Your Ref
BE/104/11/
Our Ref
S/AR/2011/104
Date: 15/08/2011

Proposal: Erection of a detached single garage. Amendments to BE/51/08 (Re-submission following BE/57/11).

Site: Land Adjacent 37, The Croft, Bognor Regis, West Sussex PO21 5TH.
BE/104/11/

Drawing PG04 July 2011 Scale 1:500 / 1:1250
Block Plan and Location Plan

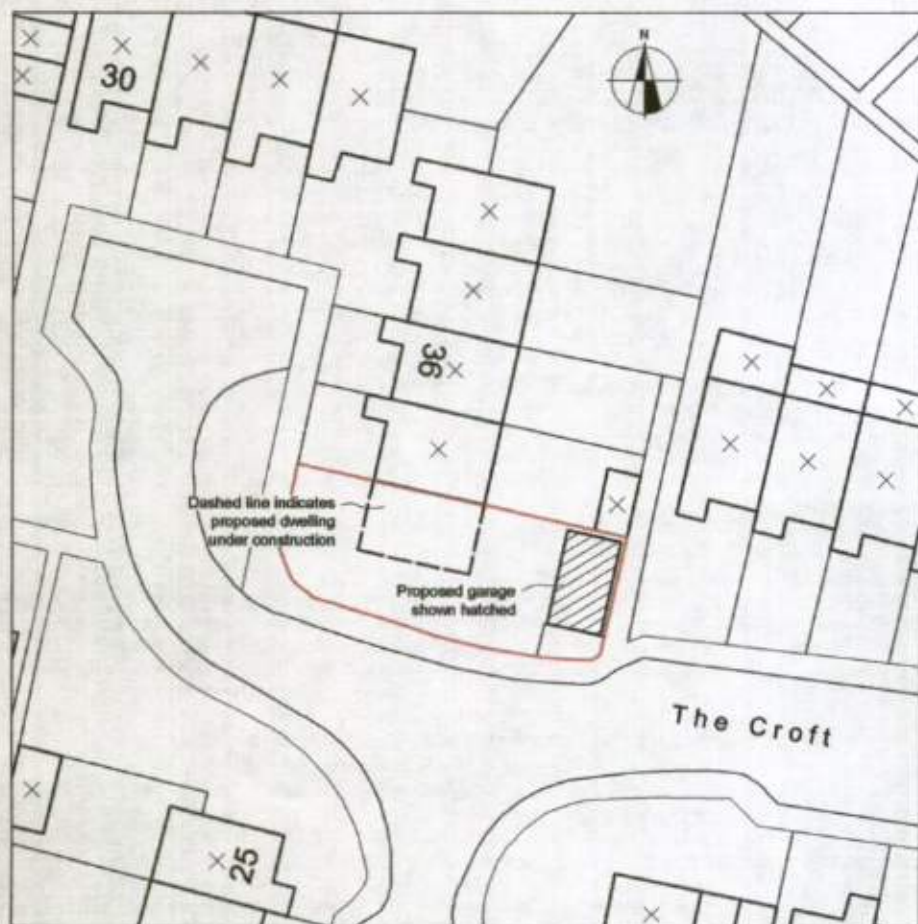
Please find attached a plan of the sewer records showing the approximate position of a public sewer crossing the site. The exact position of the public sewers must be determined on site by the applicant before the layout of the proposed development is finalised. Please note:

- No development or new tree planting should be located within 3 metres either side of the centreline of the public sewer.
- All existing infrastructure should be protected during the course of construction works.
